**Consultation Response from KC,
Highways Development Management**

2024/93506 Land at, Old Lane/Taylor Lane, Scapegoat Hill, Huddersfield, HD7 4ND

Discharge of details reserved by condition 4 (external materials), 6 (Phase I Report), 7 (Phase II Report), 8 (Remediation Strategy), 9 (Remediation works), 11 (road widening), 12 (construction traffic), and 13 (retaining structures) on previous permission 2024/91524 for erection of two detached dwellings

Date Responded: 4-3-2025.

Build Vision Consulting Engineers

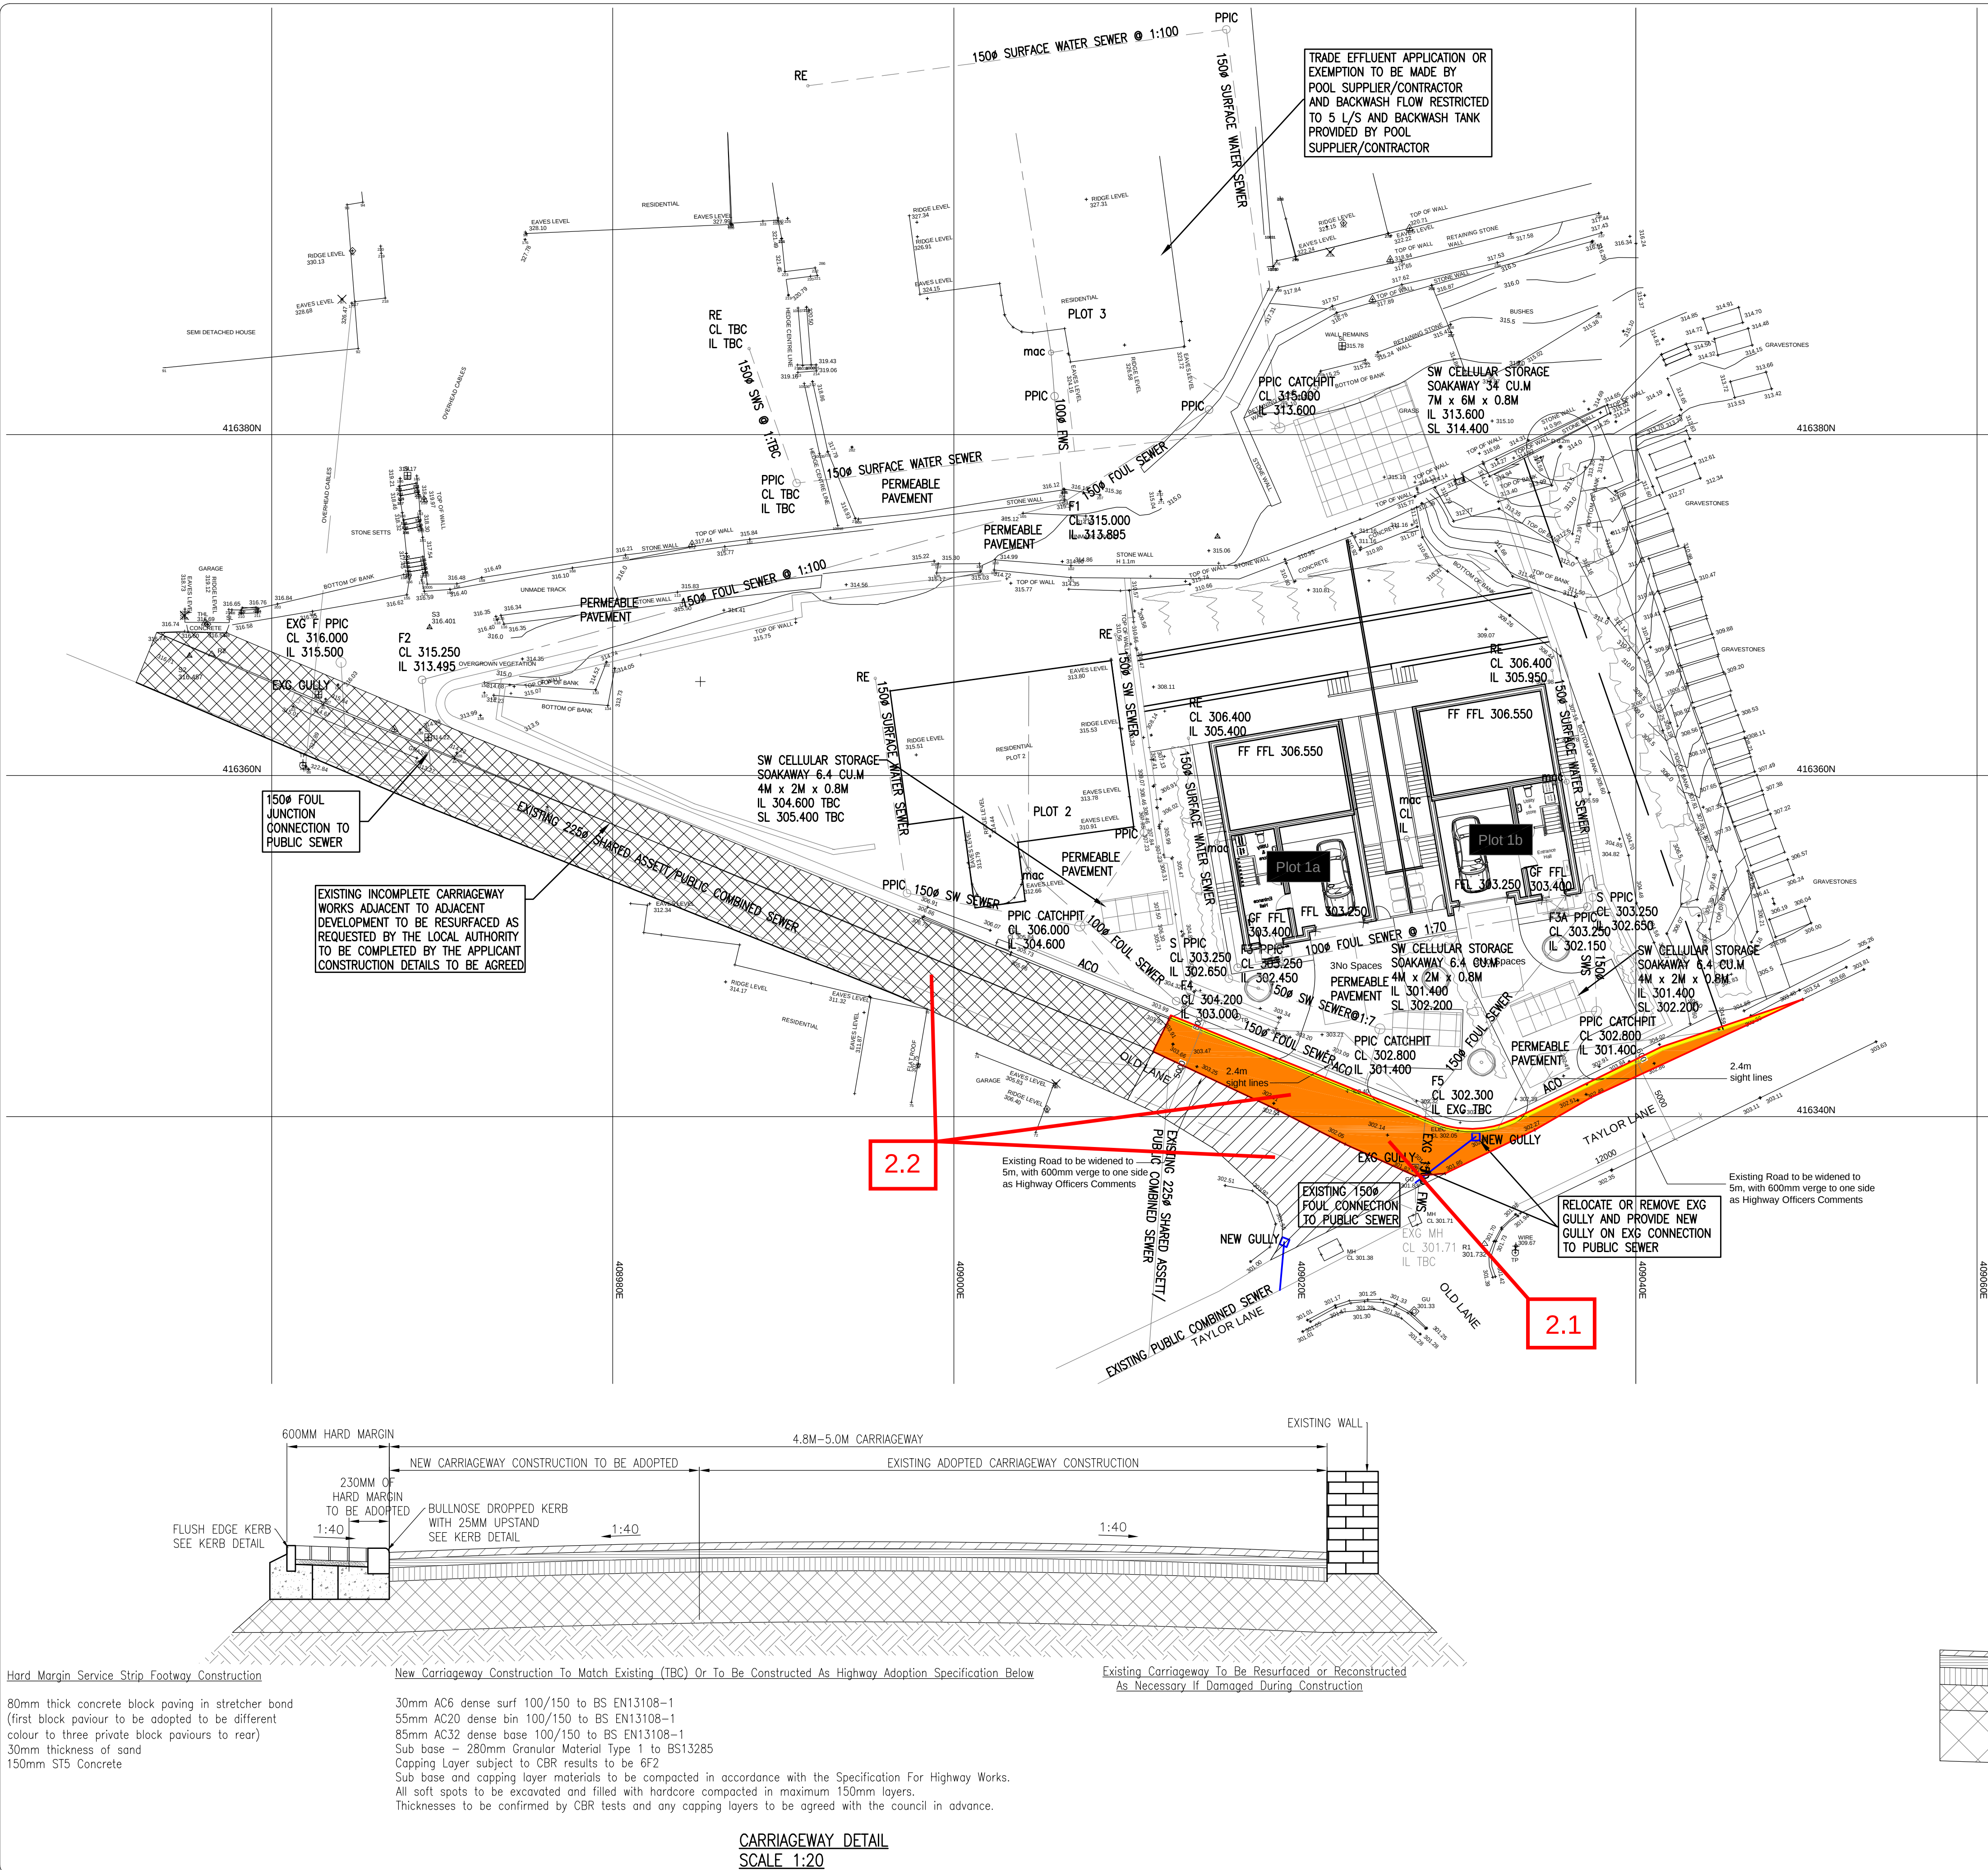
The Build Vision plan shows full carriageway construction details, kerbing, edging and new gully locations. New full construction is shown shaded orange and resurfacing is shown cross hatched. These works only deal with the area of road to the front of the applicants own plot which is not considered acceptable.

A further plan was submitted on 26th February directly to Highways Development Management (HDM) by James Bradley at Violet Homes showing the extent of the surfacing works increased to include the full frontage of the plots completed by the previous developer Briestone Ltd.

As far as the extent of the works are concerned the applicant's proposals are now considered acceptable to H D M.
